**Block 4B Central Park Adaptive Reuse (SSD-9374 and MP06_0171 MOD 16)
Request for Additional Information**

I refer to your application for Adaptive Reuse of the Brewery Building, Central Park. The Department has reviewed your response to submissions and requests that you provide additional information on the proposed panel to be constituted to review the proposal.

Figure 60 – Extract of Proposed Northern Elevation

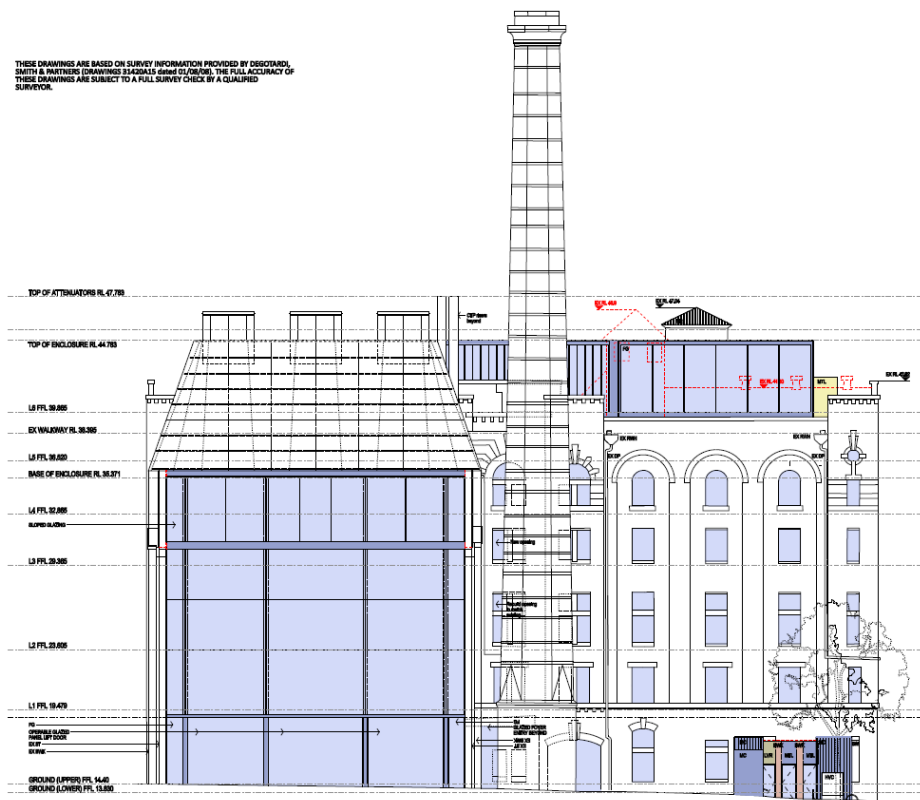
- a list of proposed panel members, and confirmation of their ability to sit on the panel
- the terms of reference for the panel outlining the purpose, scope, reference materials, conduct, meeting procedures and provision of advice. In particular, the panel must consider the issues raised by Heritage NSW and Council including:
 - the extent of intervention to the building fabric and protection of heritage value of the building and site
 - the design integrity of the northern façade and the northern part of the eastern façade.
